Storm Water Compliance Inspection Form

Inspection Type: Routine

Date: 06-15-2021

Owner: Presbyterian Healthcare Services

**EROSION
& SEDIMENT
CONTROL PLAN**

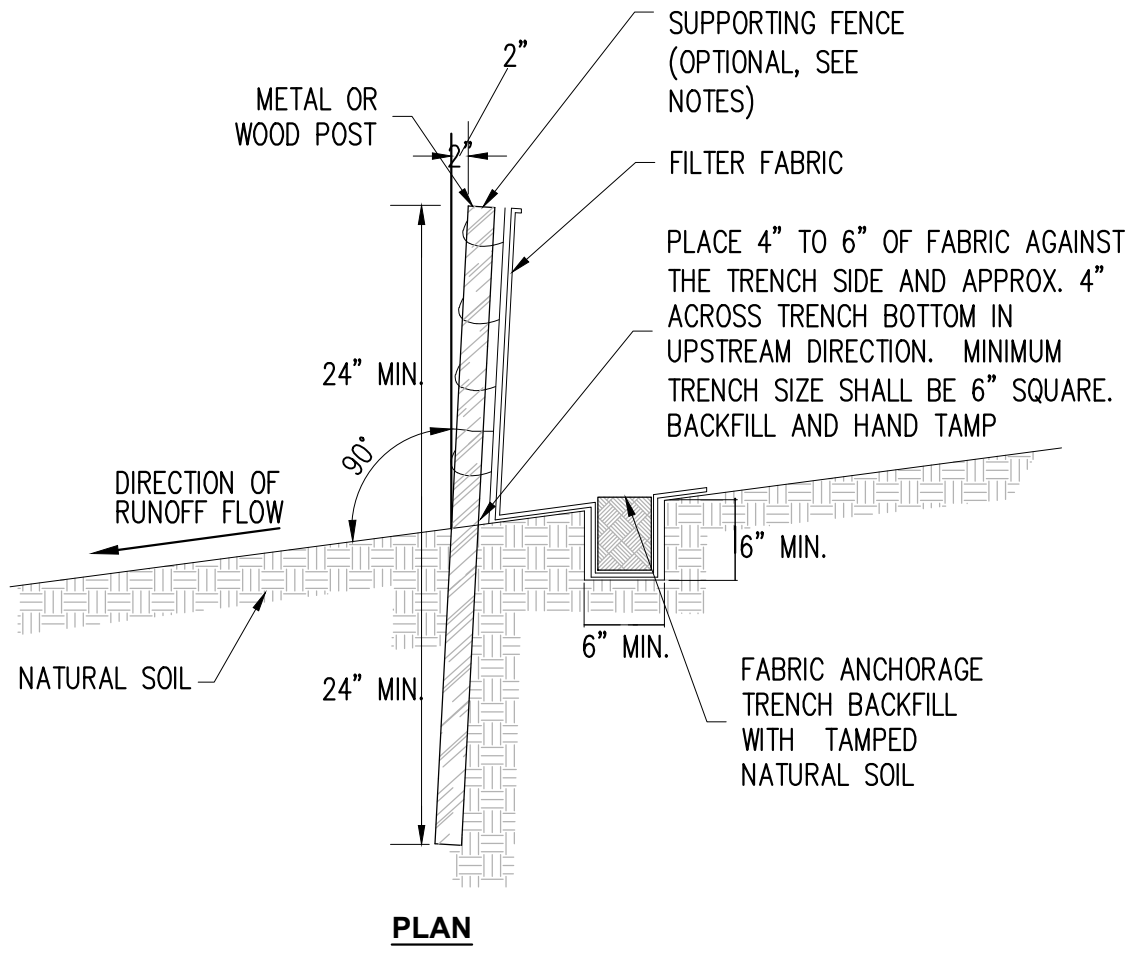
Waste Management	<input checked="" type="checkbox"/>	<input type="checkbox"/>	<input type="checkbox"/>	
Vehicle Tracking Control	<input type="checkbox"/>	<input checked="" type="checkbox"/>	<input type="checkbox"/>	Refresh trackout at NW corner of site.
Material Storage	<input checked="" type="checkbox"/>	<input type="checkbox"/>	<input type="checkbox"/>	
Dust Control	<input checked="" type="checkbox"/>	<input type="checkbox"/>	<input type="checkbox"/>	
Street Sweeping	<input type="checkbox"/>	<input type="checkbox"/>	<input checked="" type="checkbox"/>	Sweeping is being done as needed
Construction Washouts i.e. Concrete, Paint, Stucco Etc.	<input checked="" type="checkbox"/>	<input type="checkbox"/>	<input type="checkbox"/>	
Discharge Points	<input checked="" type="checkbox"/>	<input type="checkbox"/>	<input type="checkbox"/>	
Sanitary Stations	<input checked="" type="checkbox"/>	<input type="checkbox"/>	<input type="checkbox"/>

Location	Action Type	Action Required	Date Noted	Date Completed	Initials
Silt fence	Maintenance	Silt fence needs to be repaired	03-02-2021		
Silt fence on storage yard south end	Corrective Action	Need silt fence installed	06-15-2021		
South East perimeter	Corrective Action	Silt fence needs to be installed	06-15-2021		
West perimeter	Corrective Action	Need to clean and adjust inlet protection	06-01-2021		
South west entrance	Corrective Action	Inlet protection needs to be replaced and cleaned	06-15-2021		
North west entrance	Maintenance	Refresh trackout pad at NW corner of site.	12-15-2020
